Subject: RE: Planning Consultation on: WA/33/21/DOC

Engineers Comments Regarding Surface Water Drainage

Application No: WA/33/21/DOC

Description of Works: Approval of details reserved by condition imposed under ref WA/103/20/HH relating to Condition No 3 - surface water drainage.

450mmØ Polypipe basic silt trap detail

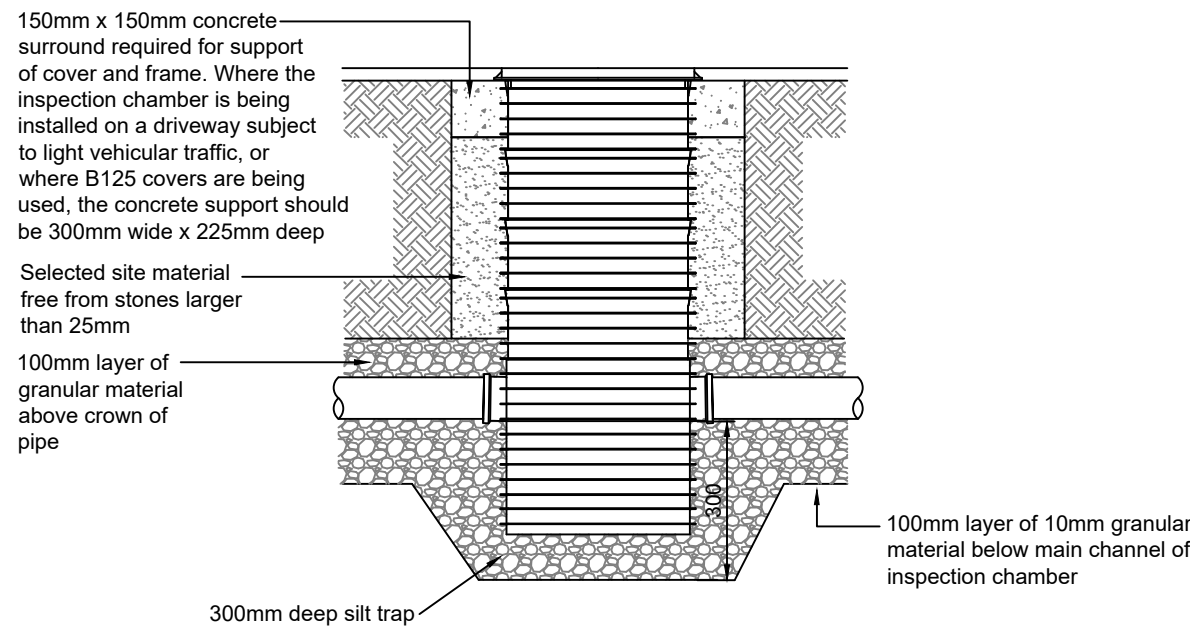
All the calculations and construction details are acceptable, however, there is a single minor inconsistency with the Drainage Layout, the silt trap is shown as 500mm diameter on Drainage Layout but as 450mm diameter on construction detail drawings and calculations. Once the Drainage Layout has been corrected and resubmitted I shall be recommending that the condition is discharged.
